Consultation Response from: KC Environmental Health (Pollution & Noise Control)

2025/92161 - Land adj 17 Whitehall Road West, Birkenshaw, BD11 2LS

Discharge of details reserved by conditions 4-8 (intrusive investigations), 11 (Remediation Strategy and Verification Report), 12 (CEMP), 13 (noise), 14 (Arboricultural Method Statement), 15 (CMP), 16 (highway), 17 (visibility), 18 (Safety Audit), 19 (estate streets), 20 (waste collection), 21 (surface water attenuation), 24 (bin storage), 25 (bicycle storage), 26 (drainage), 28 (drainage), 29 (CEMP: Biodiversity),-30 (landscape), 34 (solar panel array), 35 (materials), 38 (boundary treatments) on previous permission 2024/92281 for erection of 23 dwellings

Condition 13 (Noise)

Appendix 5 Façade Mitigation Measures

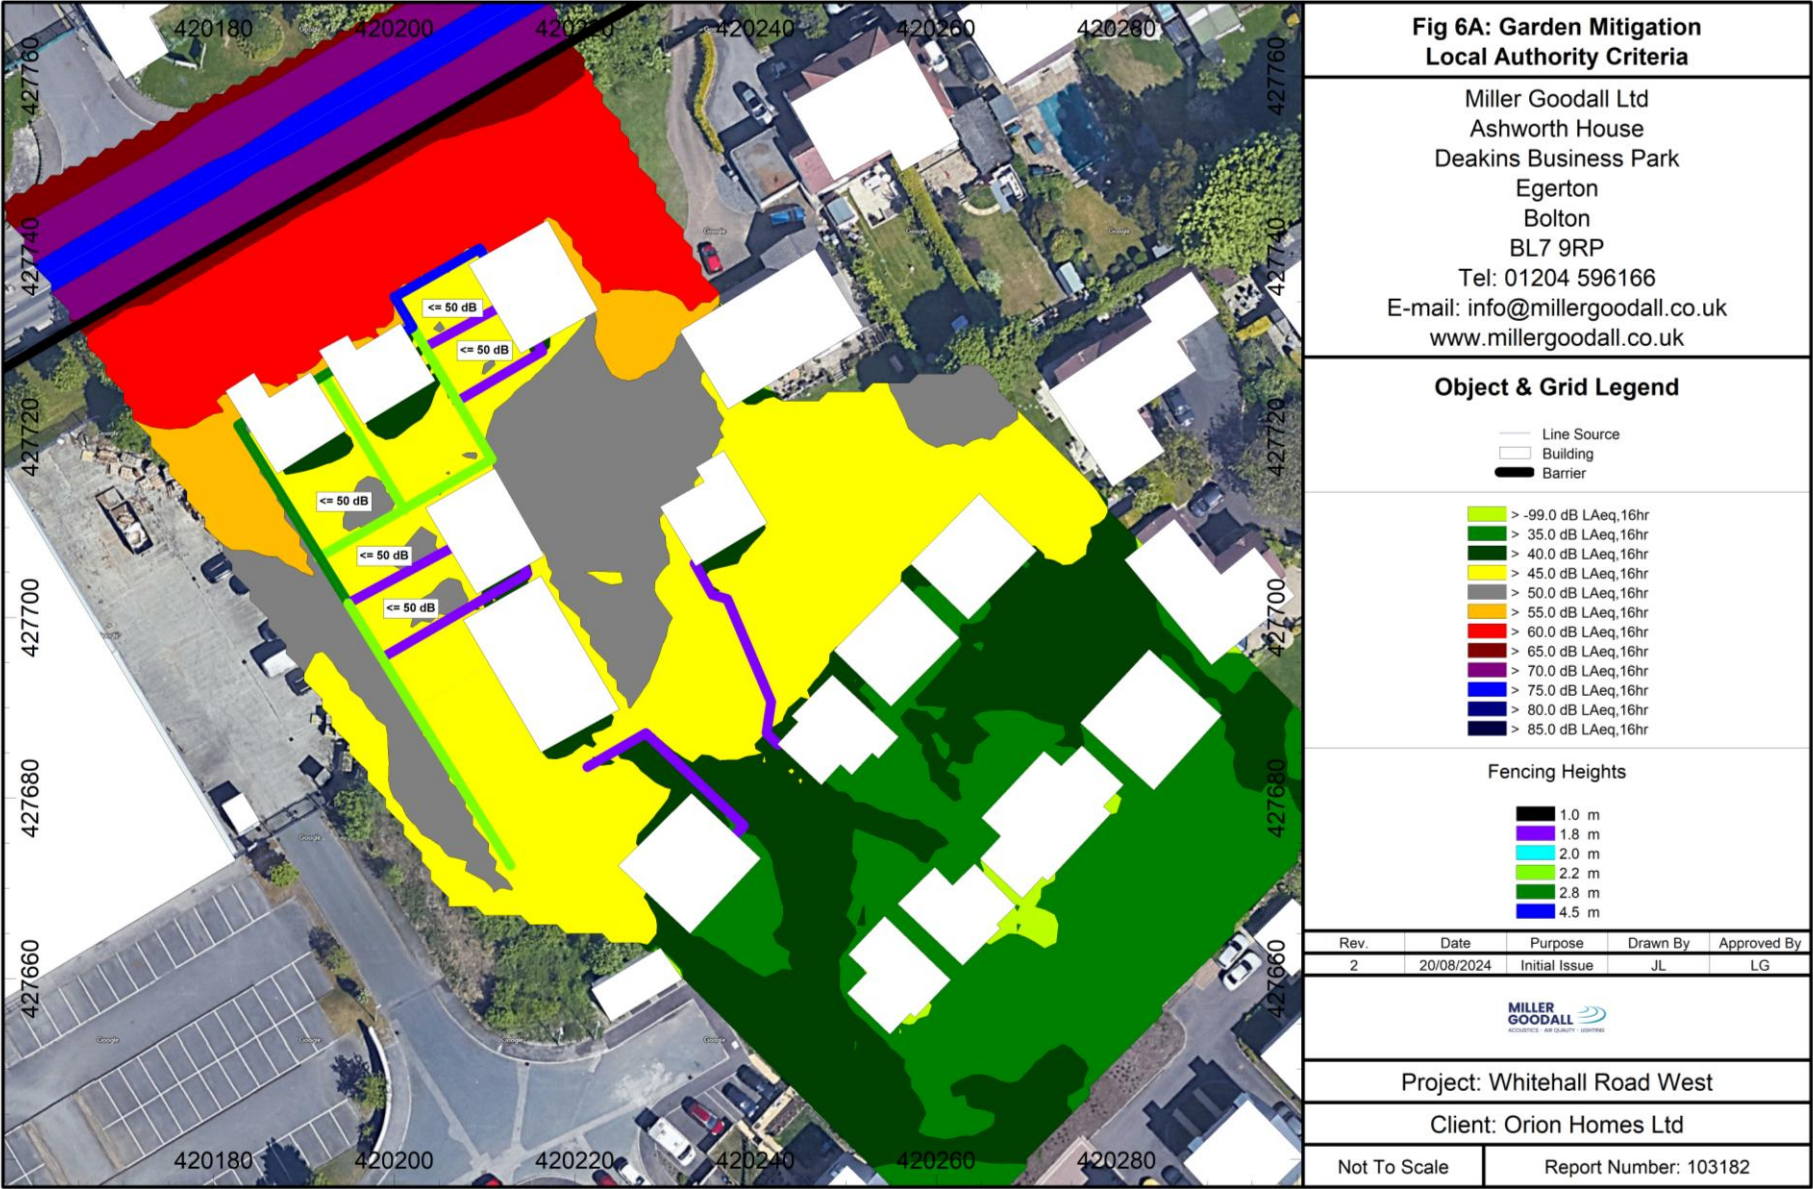
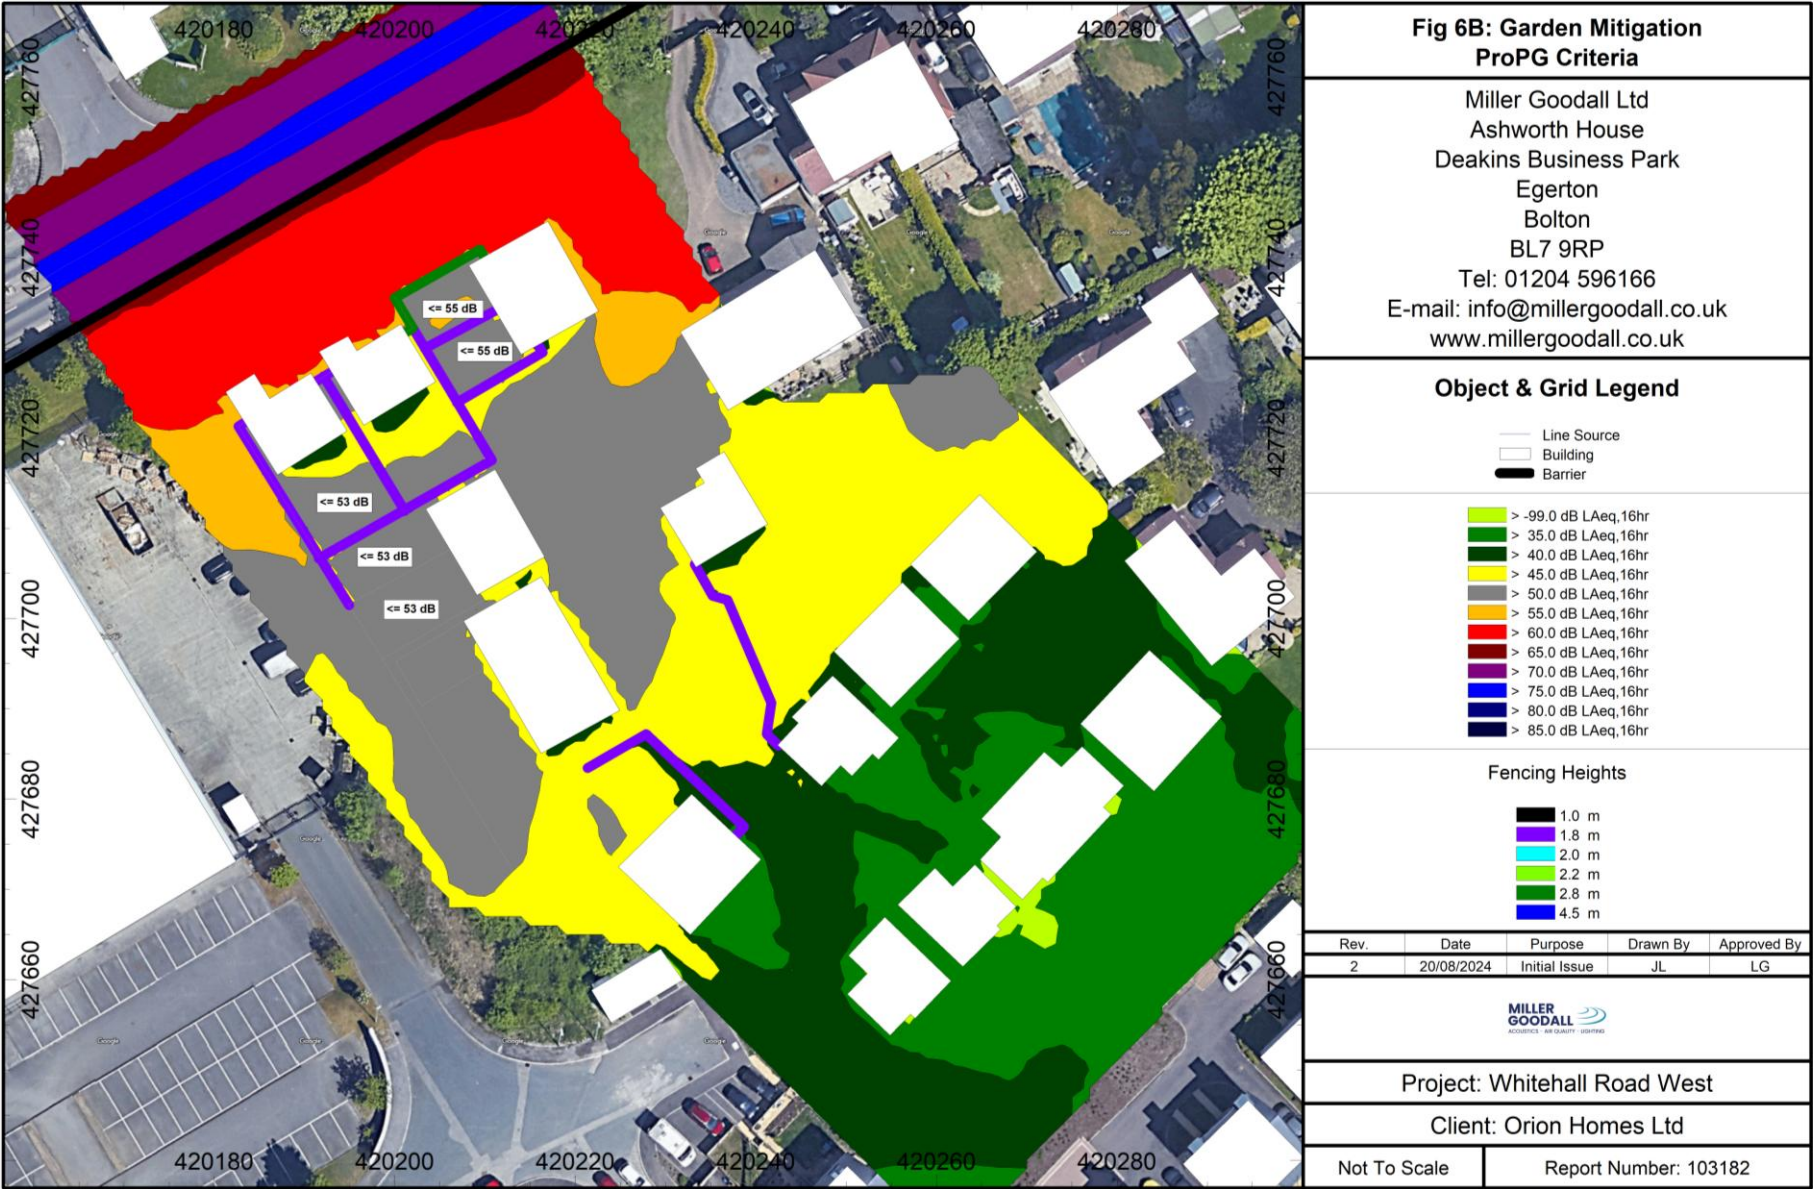
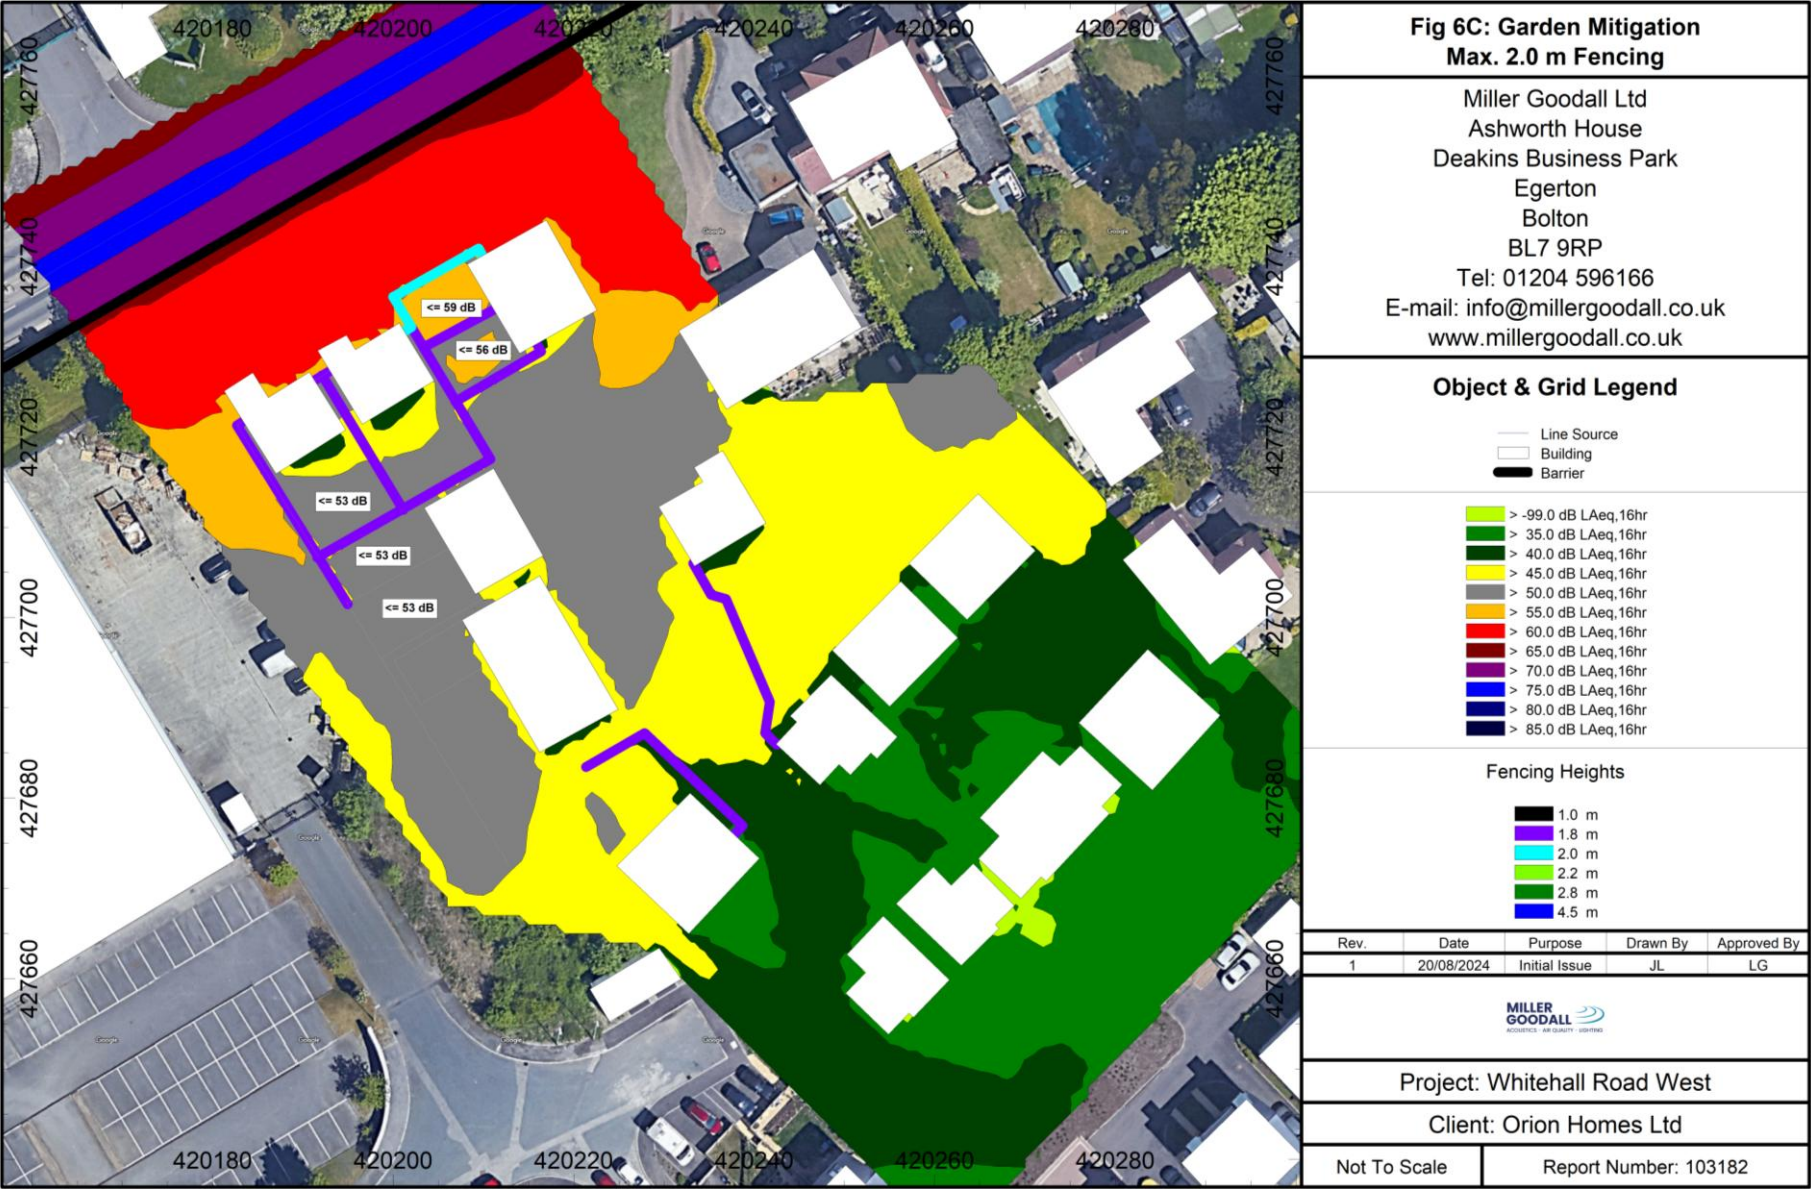
In our previous comments, we noted that the submitted Noise Assessment did not consider the use of the neighbouring West Yorkshire Fire and Rescue Services HQ as a fully operational Fire Station and not simply as a training facility with parking space for smaller first-responder type vehicles. The applicant has submitted a Planning Noise Assessment authored by Miller Goodall dated 12 November 2025 Ref 103182 V4 with para 6.3 making reference to the use of the sirens from the site.

The findings of the report remain with mitigation measures required in order to meet with the requirements of BS8233. Internally, glazing and ventilation is specified according to the façade (1 - ground floor and 2 – first floor) with comment made that it would be appropriate to use façade 1 throughout the site but not façade 2 and that all façades marked with green may utilise openable windows. This is reflected in the colour coded plan within Appendix 5. Externally, acoustic barriers of varying heights are proposed as shown in Appendix 6. Para 10.3 states that in order to achieve the desired level of 50dB LAeq,16hr, a 4.5m high barrier would be required which we agree, would be unreasonable. A 2m high barrier would only afford mitigation to 59dB LAeq,16hr which exceeds the upper guideline value of 55dB LAeq,16hr but BS8233 does state ‘... , it is also recognized that these guideline values are not achievable in all circumstances where development might be desirable. In higher noise areas, such as city centres or urban areas adjoining the strategic transport network, a compromise between elevated noise levels and other factors, such as the convenience of living in these locations or making efficient use of land resources to ensure development needs can be met, might be warranted. In such a situation, development should be designed to achieve the lowest practicable levels in these external amenity spaces, but should not be prohibited.’ The alternative is for a 2.8m high barrier to be installed which would ensure the external amenity areas meet with the upper limit of 55dB LAeq, 16hr and it is for the Planning Officer to determine which of these options is acceptable.

The submitted information is accepted. However, we recommend the condition is not discharged as the mitigation measures recommended within the Planning Noise Assessment

authored by Miller Goodall dated 12 November 2025 Ref 103182 V4 must be implemented and retained thereafter.

The findings of the report are accepted.
